Engineers Comments Regarding Surface Water Drainage

Application Reference:	BE/17/26/S73	Reviewer Reference:	ADC/EXT5/AF
Planning Officer:	Simon Brooksbank	Date of Review:	05/06/2026
Site Name:	Chalcroft Nurseries Land at Chalcraft Lane Bersted PO21 5TS		
Application Description:	Variation of condition 20 following approval of BE/148/20/OUT relating to rewording of condition.		
Assessment Number:	2

Site: **Nursery Fields, Bersted**
Title: **Site Phasing Plan**
Dwg No: **A437-DD-1000**

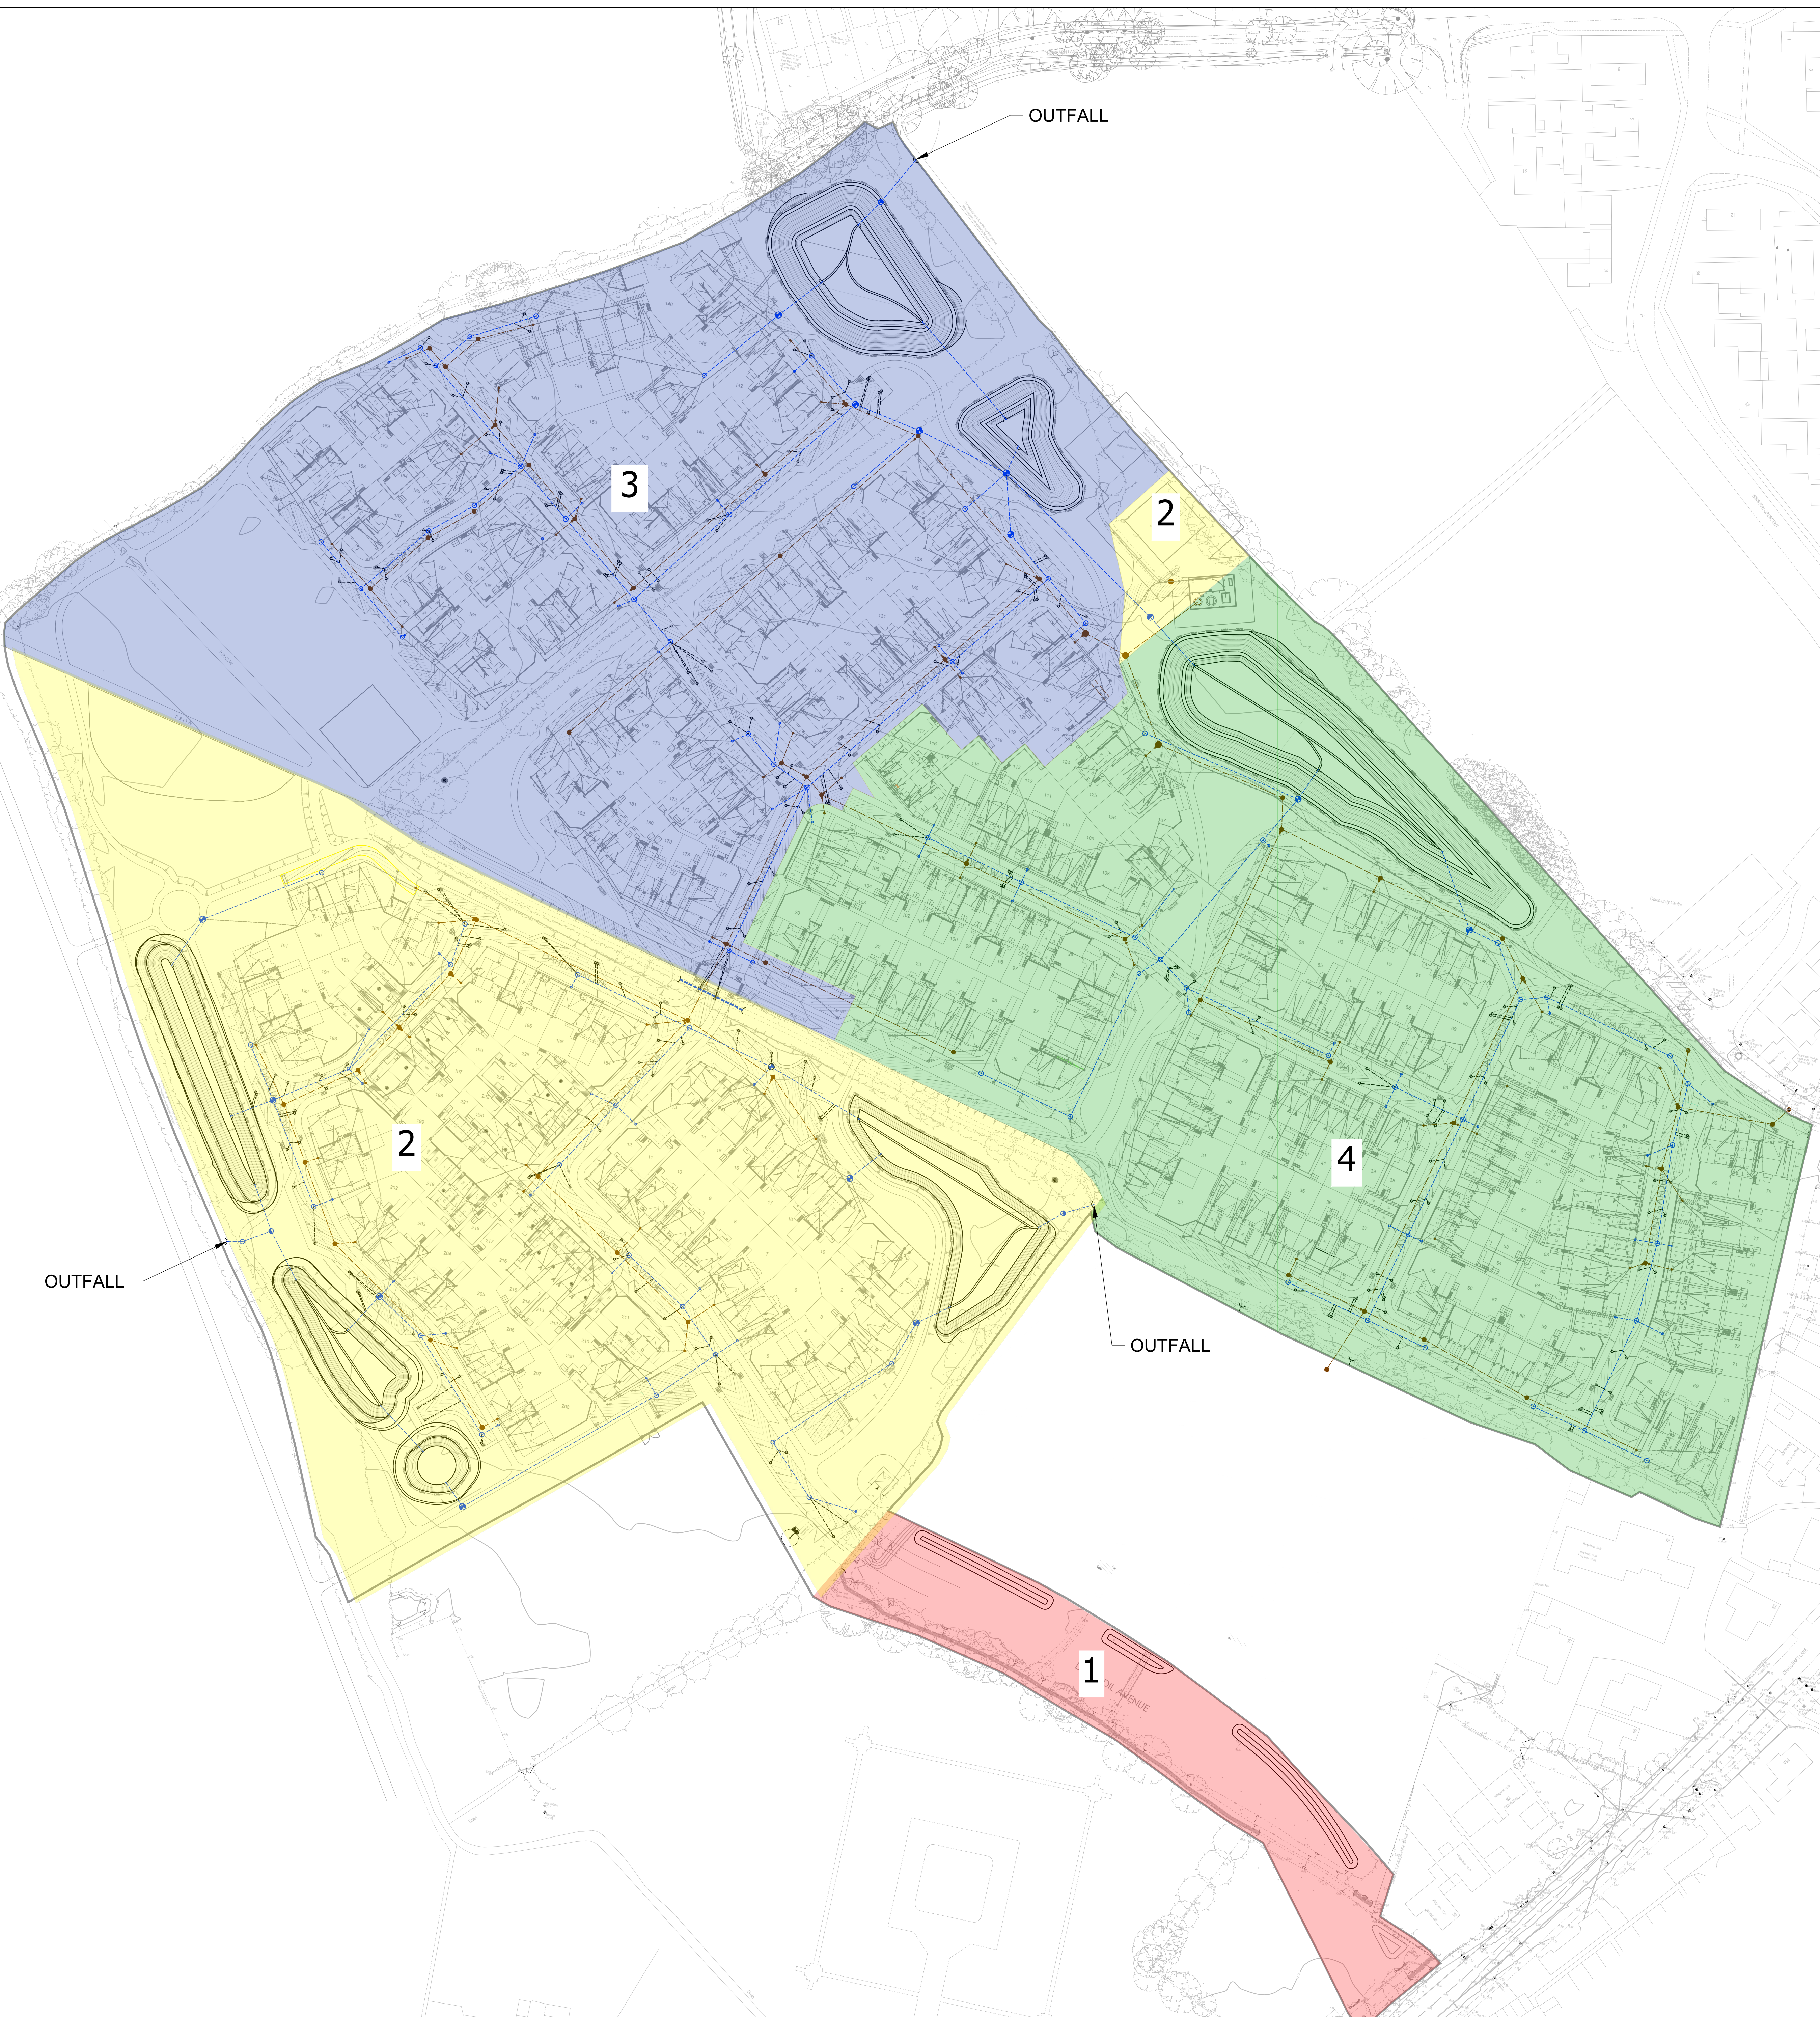
The Site Phasing Plan A437-DD-1000 Revision B dated 05/26 is acceptable as a basis for the alteration of Condition 12 to an ‘each phase’ basis.
